Applicant Response to TfL (Stage 1)

Planning Application Reference 2382/APP/2023/2906
Broadwater Lake, Moorhall Road, Harefield, UB9 6PE

Appendix C – General arrangement access design

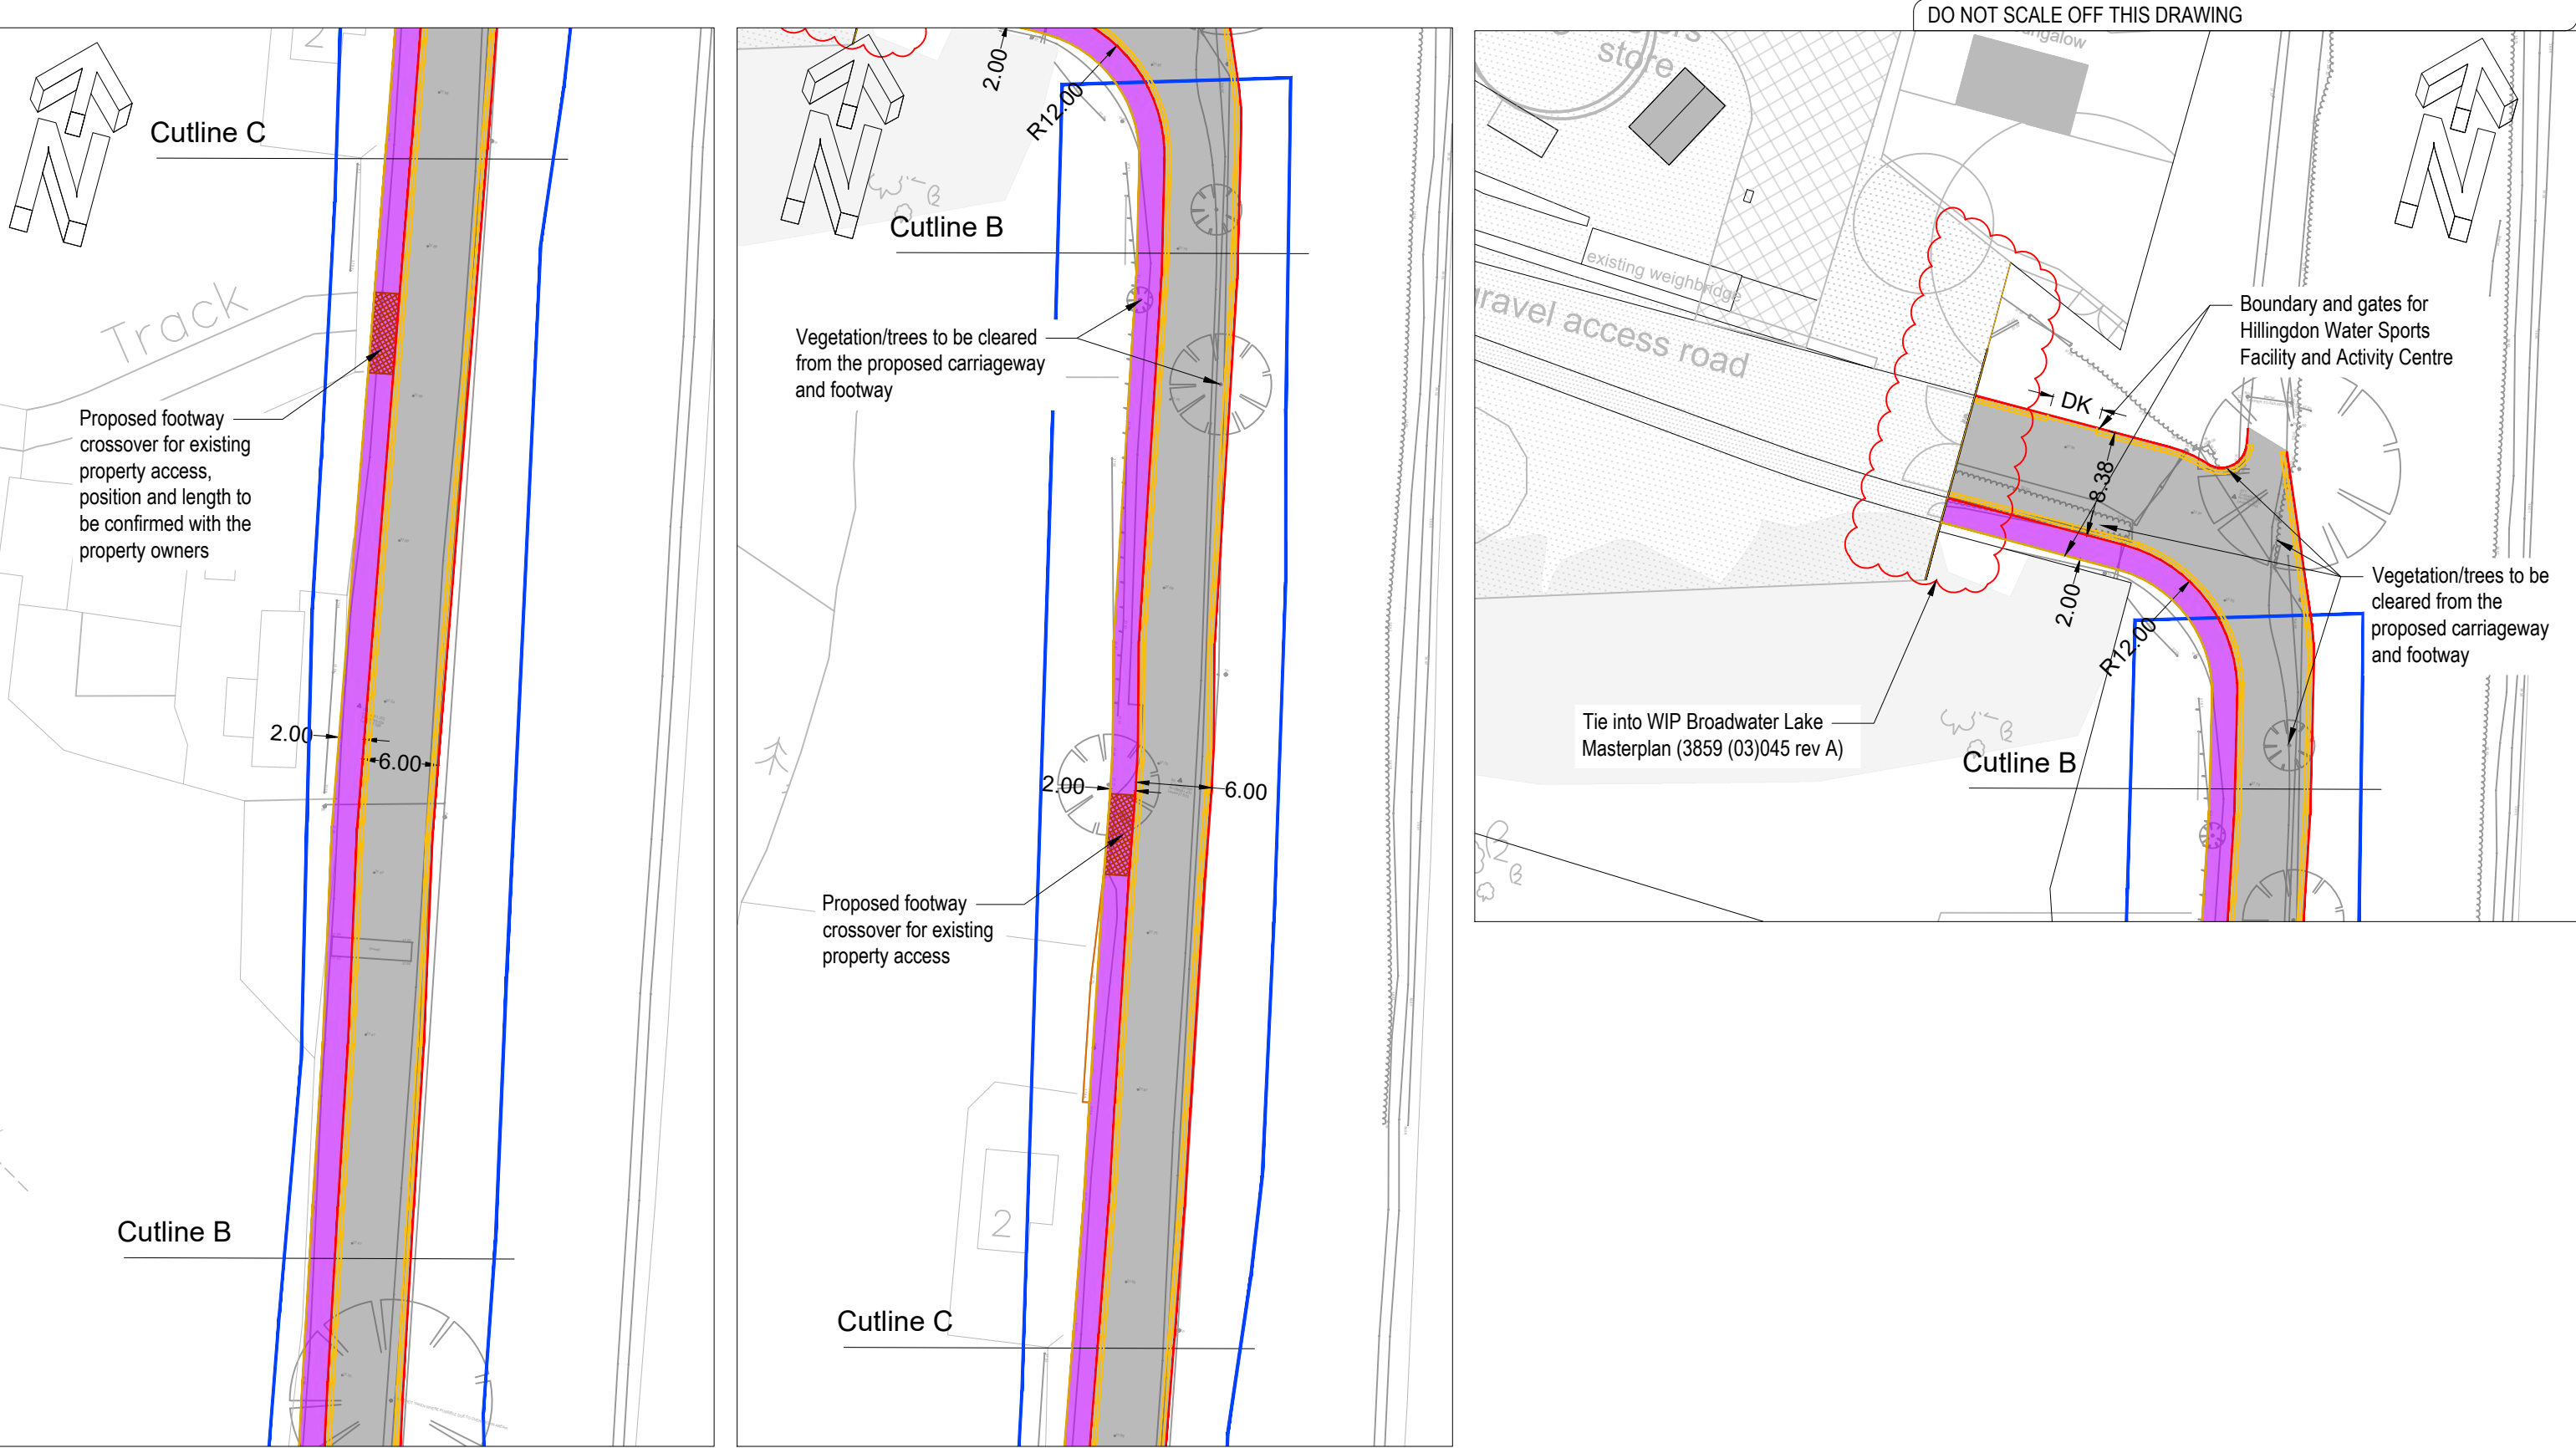
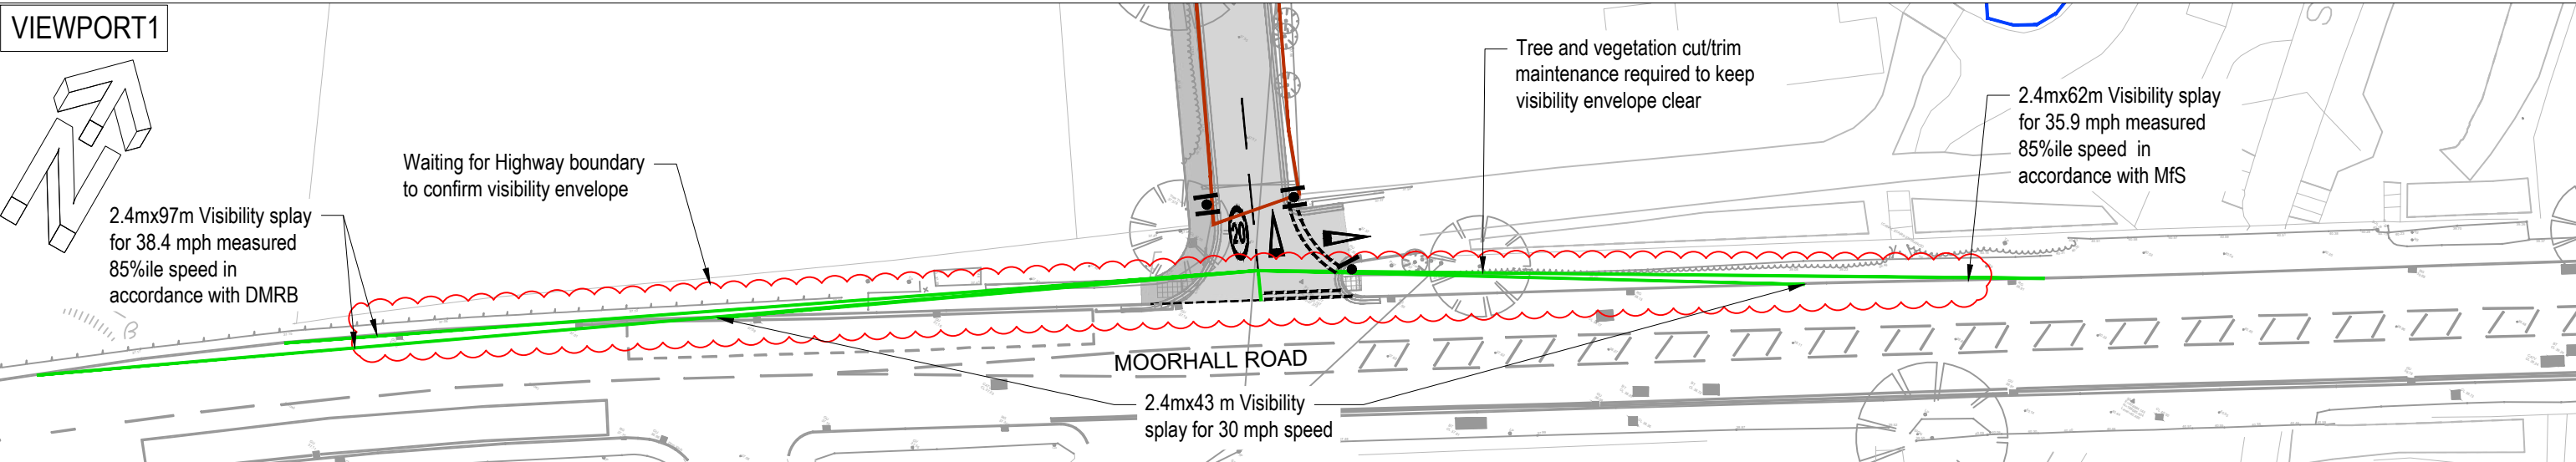
<p>Healthy Streets approach, with priority given to modes of sustainable and active travel over that of private vehicle. On the General Arrangement Plans there are several stretches of access road where the footpath changes sides without any crossing or demarcation. This should be addressed</p>	<p><i>intended point of adoption. A 1.2m marked footway will be continued along the eastern side of the access road.’ AND ‘A marked crossing point proposed at the northern end of the access road will connect the proposed footway to the pedestrian entrance to the site.’ – This has been addressed.</i></p>	
Healthy Streets		
<p>In line with policy T1 the development should promote travel by sustainable modes and active travel. A daytime Active Travel Zone (ATZ) assessment has been undertaken in accordance with TfL guidance in line with the Healthy Streets approach providing a detailed review of the ATZ surrounding the site. However, it should be extended to include how the site connects to the Grand Union canal and other public footpaths that are within proximity to this site.</p>	<p>This has not been addressed. TfL reiterate that routes should be extended to include how the site connects to the Grand Union Canal and other public footpaths. This is important to ensure the application meets the mode share targets to comply with London Plan policy T1.</p>	<p>The connectivity of the Site to the Grand Union Canal has been carefully considered by the Applicant team in order to meet the statutory safeguarding requirements of future users, such as school students and younger or more vulnerable people. The proposed development must meet stringent safeguarding and security standards to the level of educational institutions. The statutory requirements for security include the Department of Education Statutory Guidance on Keeping Children Safe in Education for children under the age of 18.</p>

<p>changes sides without any crossing or demarcation. Given the curved nature of the access road this could result in poorly sighted crossing by pedestrians which could endanger the safety of pedestrians and motorists. Additionally, the footpath terminates into the car park at the end where vehicles would potentially conflict with pedestrians. Additionally, the proposed footpath and pedestrian crossings need to be shown more clearly on the swept path analysis. Further information on signage and wayfinding, within the site and on adjoining streets and the canal are required to be delivered.</p>		<p>Condition No. 37 as currently drafted requires an External Lighting Scheme to be submitted to the Council for approval prior to the first operation of the development. The External Lighting Scheme shall include final details of location, height, type and direction of light sources and intensity of illumination for the entire Site, including the access road.</p> <p>The wayfinding strategy will be provided at detailed design stage. Condition No. 45 as currently drafted requires a wayfinding strategy to be submitted to the Local Planning Authority for approval, prior to the first operation of the proposed development.</p>
